Your Reference: MP 10_0107
Our Reference: NCA/20/2010
Contact: Kate Lafferty
Telephone: 9806 5393
Fax: 9806 5901

**Major Project 10_0107 – Residential Development – Buildings 1, 2 & 3
61 Mobbs Lane - Epping - Channel 7 Site (Epping Park)**

EPPING PARK, BUILDINGS 1 & 2
61 MOBBS LANE, EPPING
LANDSCAPE CONCEPT PLAN

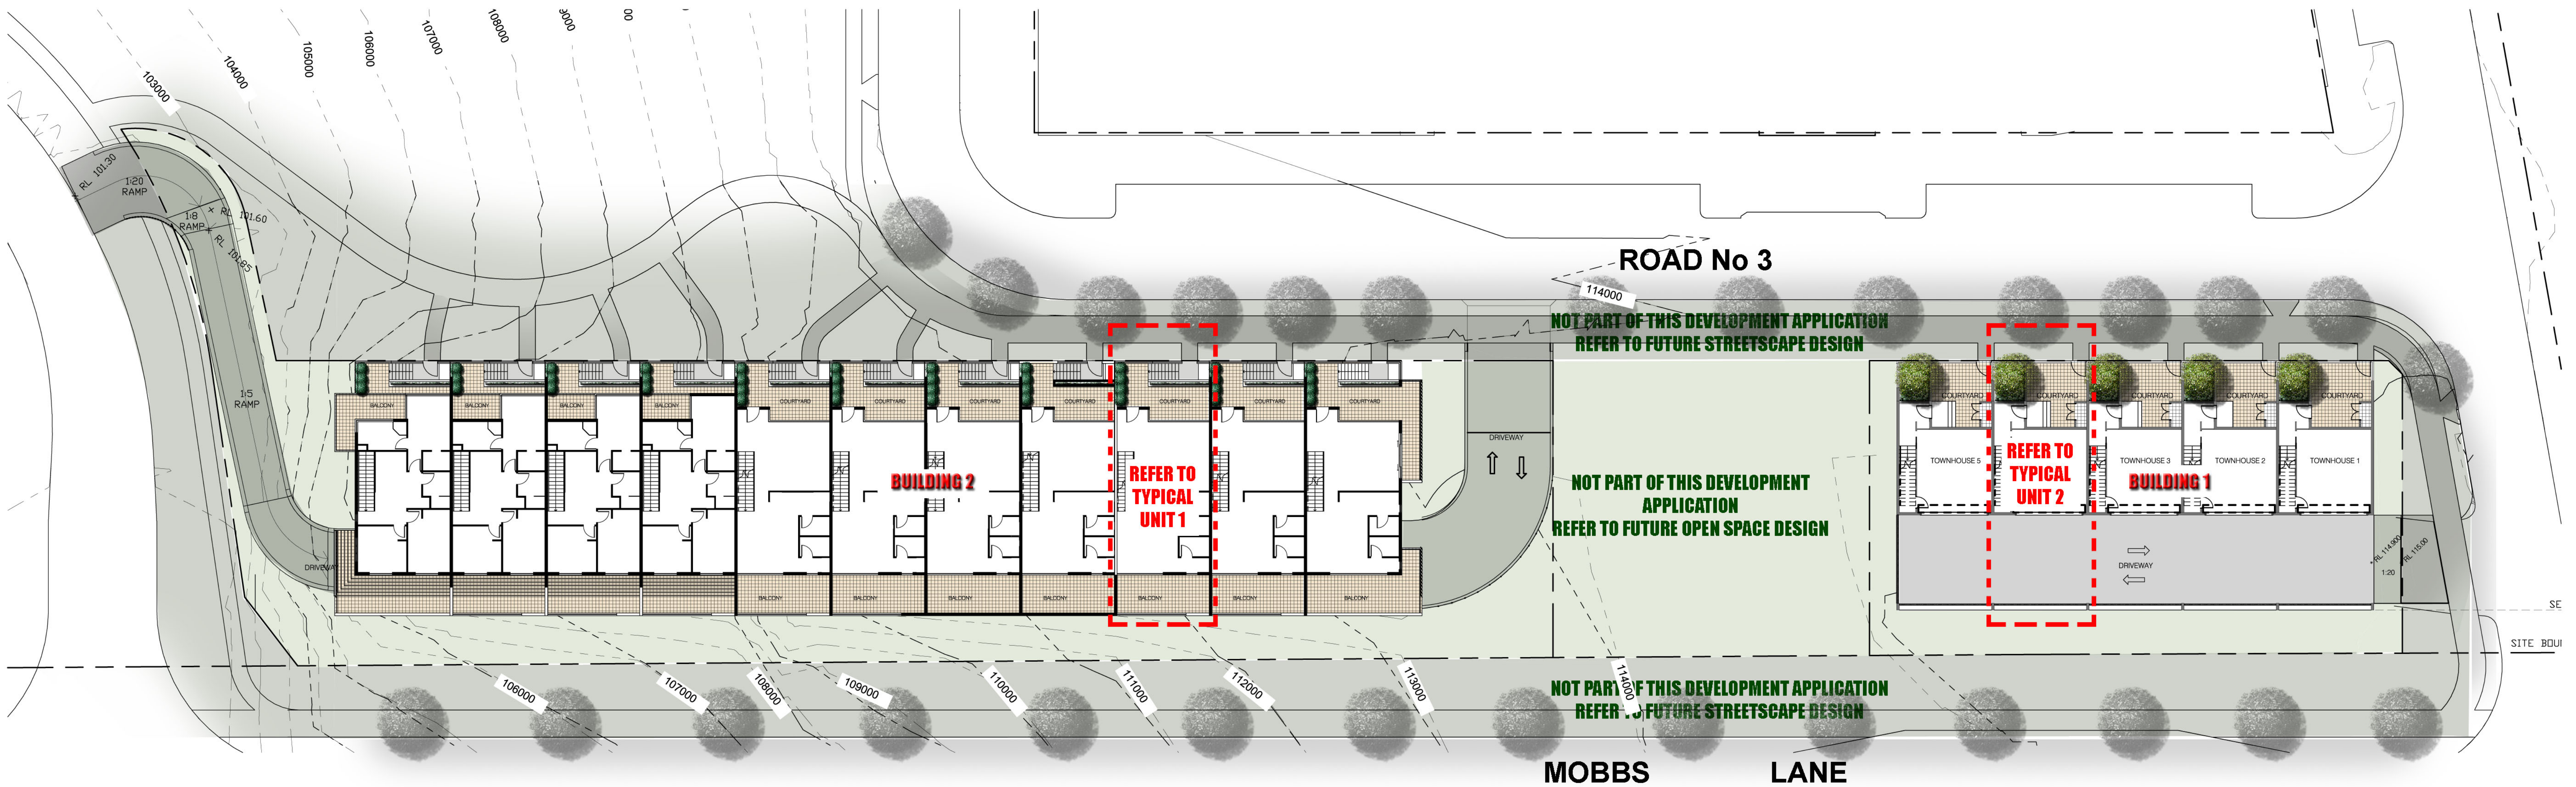
Townhouses generally provide private open space at natural ground level and Parramatta Development Control Plan 2005 requires a minimum provision of 40m² per dwelling. Front yards should not be considered or used as private open space as they are semi-private areas. Fencing should be reduced in height to provide a better integration with the public domain of the internal circulation spaces. A maximum fence height of 1.2m should be permitted with no more than 900mm from natural ground level being solid and the remainder semi transparent.

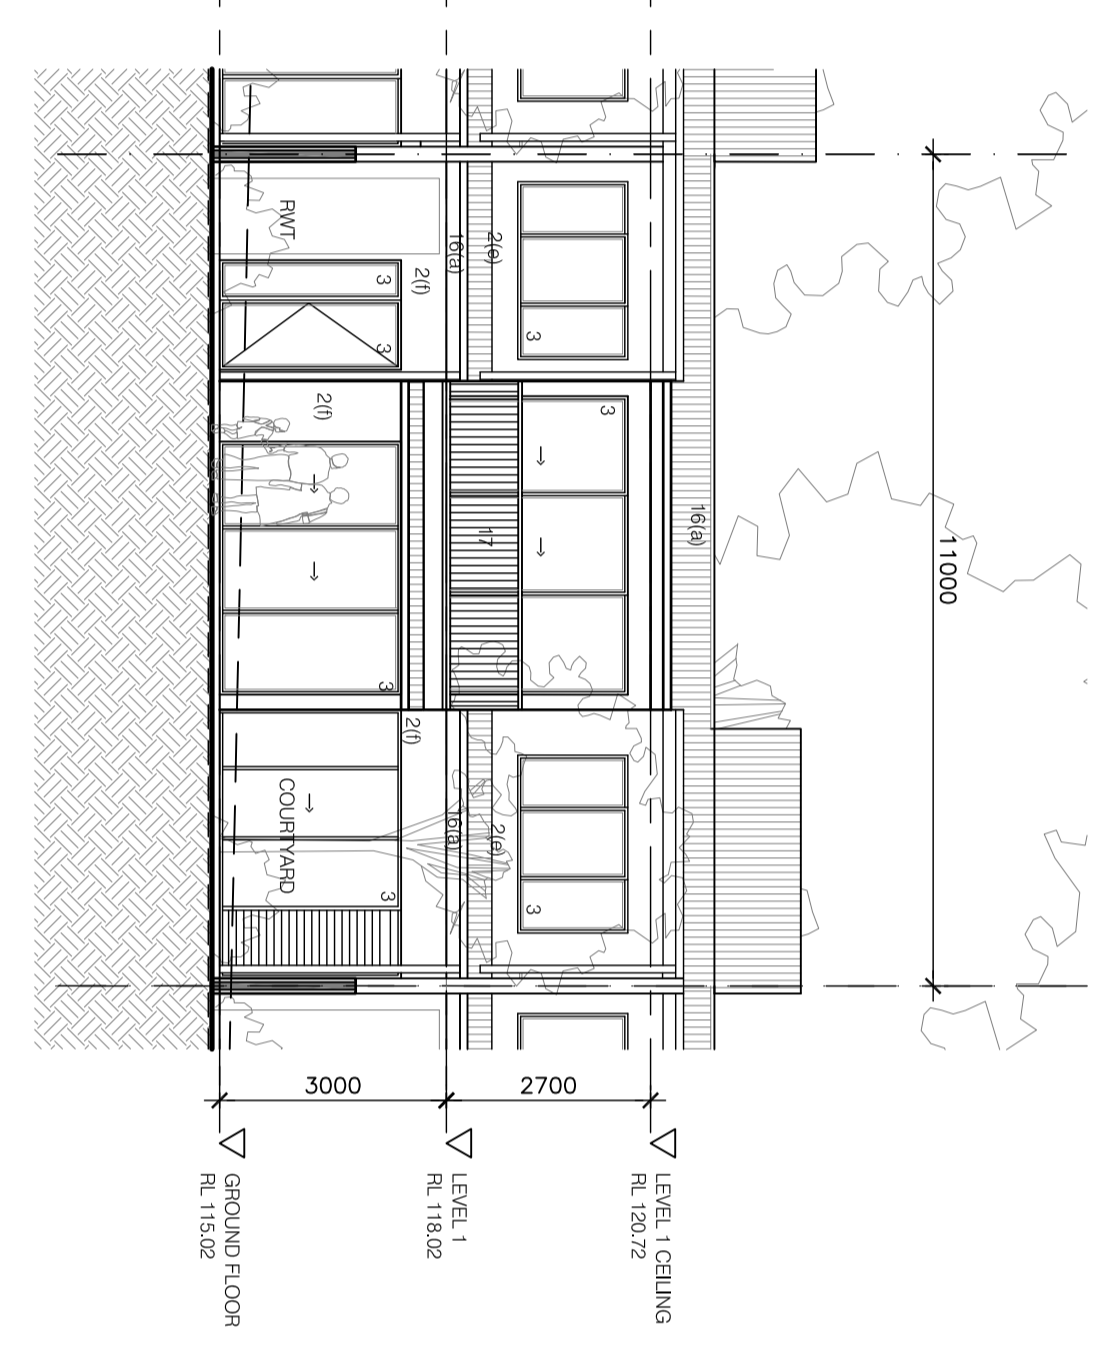
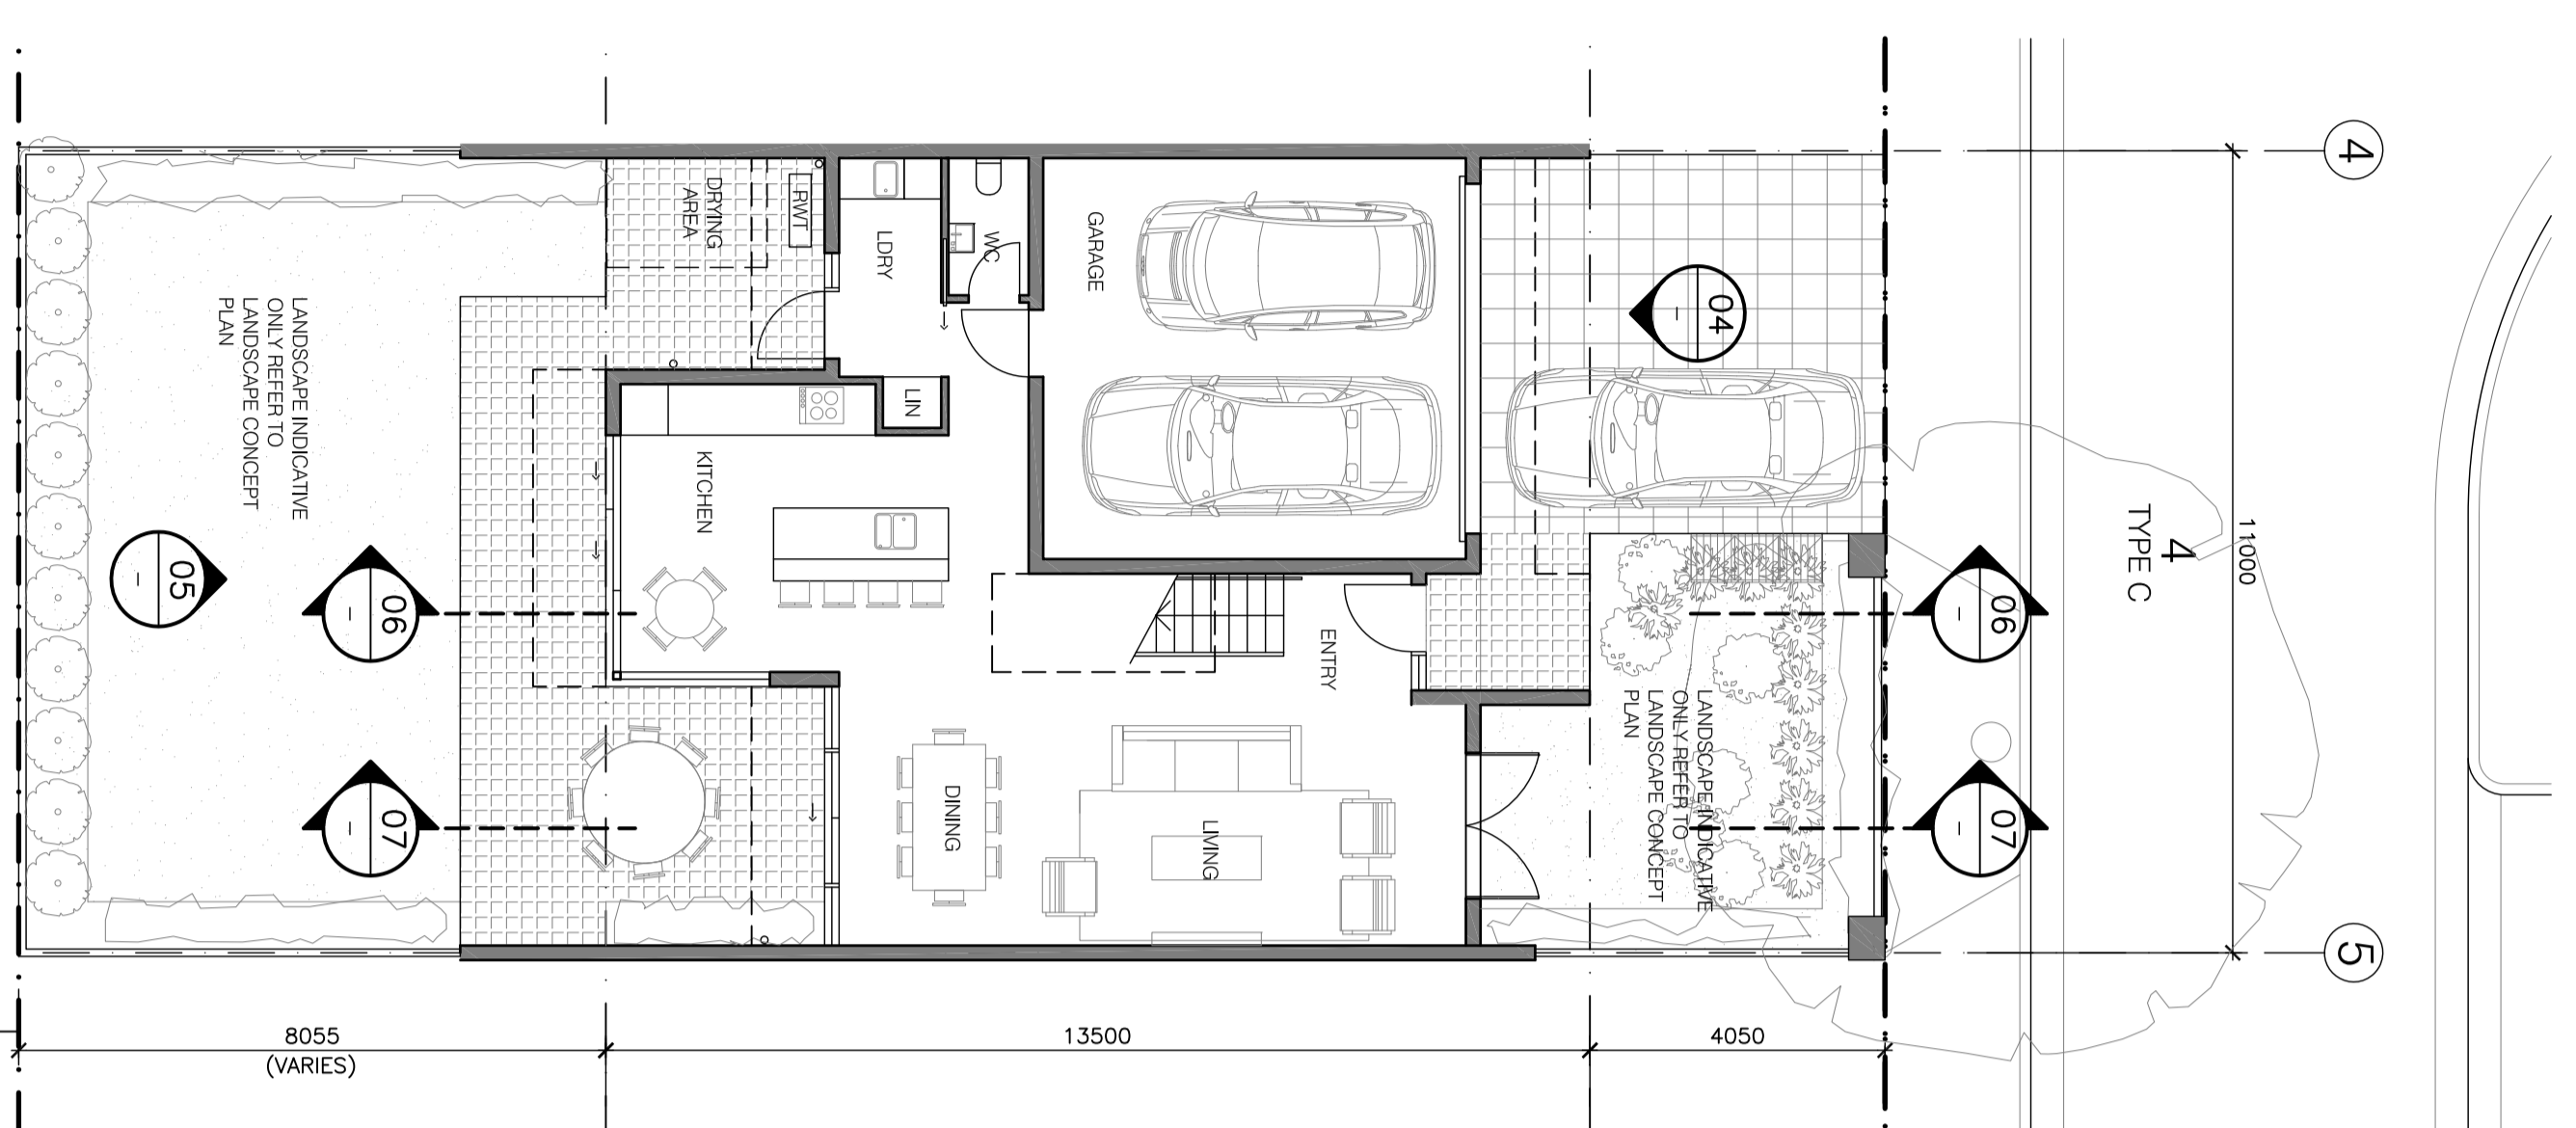
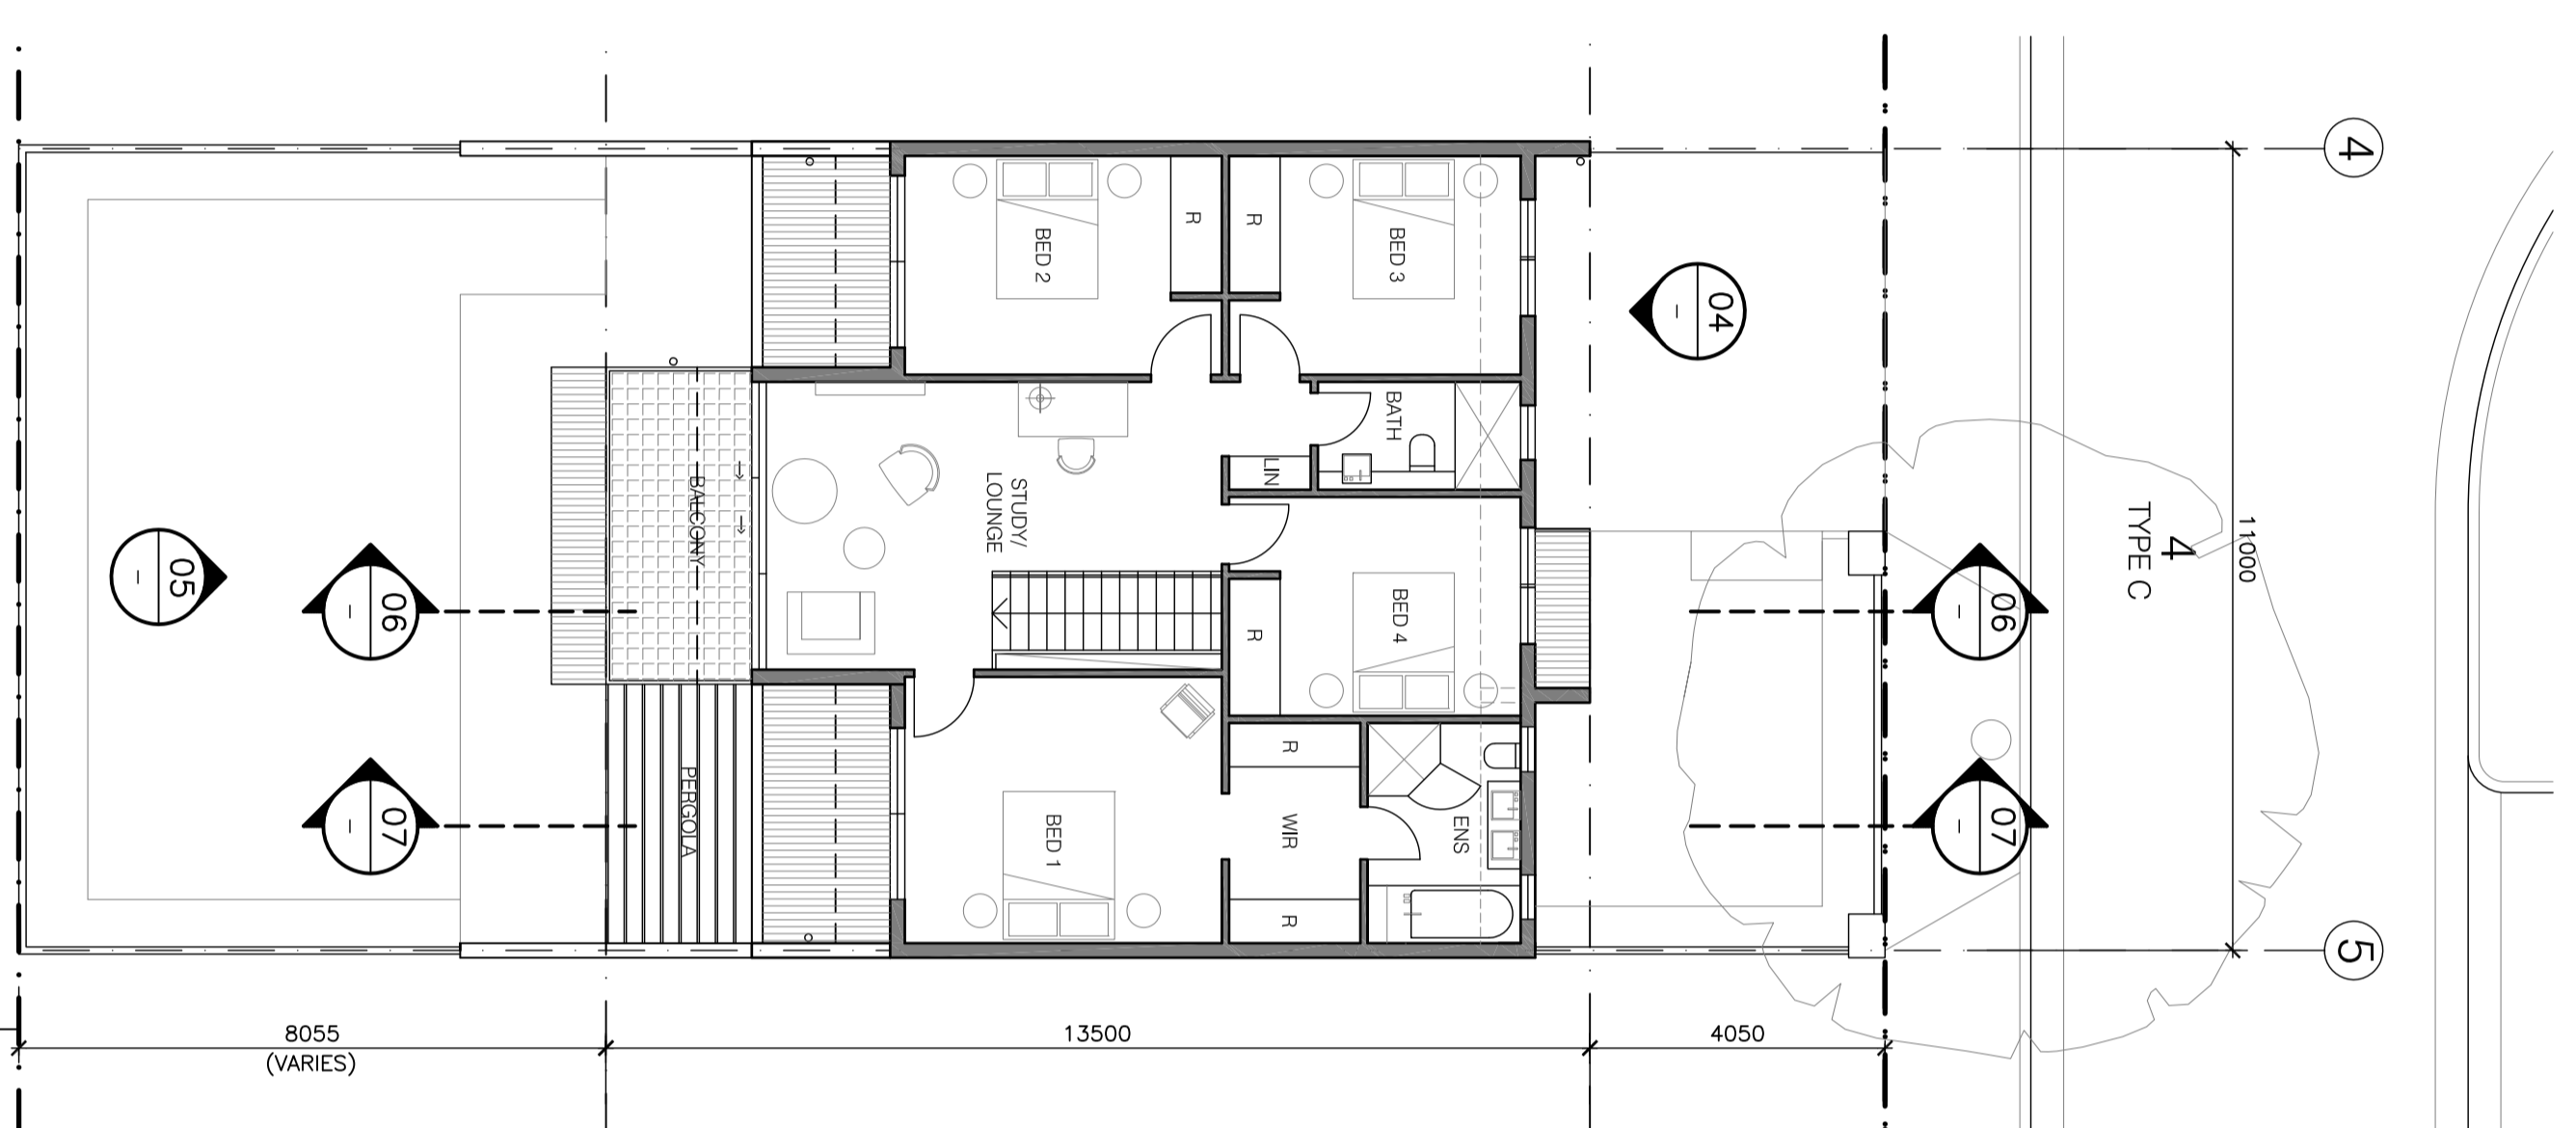
It is noted that the townhouse development has a continuous frontage of over 130m. This design conflicts with Parramatta Development Control Plan 2005 which restricts frontages of multi unit dwellings to a maximum of 20m. This is required to provide visual cohesion, continuity (including rhythm and spacing) and distinction of buildings. It is considered that the massing needs to be broken up into separate building elements.

Concern is raised with regard to the garage dominance of the proposed townhouse development. Parramatta Development Control Plan 2005 requires garages be located a minimum of 300mm behind the building line of the dwelling and be less than 50% of the front elevation. The proposed garages do not comply with these design standards and will effectively result in dominating the visual appearance of the dwellings, and thereby the internal streetscape.

The 1st floor balconies at the rear should be deleted due to the potential overlooking impacts on the adjoining properties on Edenlee Street. The balconies do not serve any benefit as private open space and their deletion would not result in any loss of amenity to the future occupants of the site.
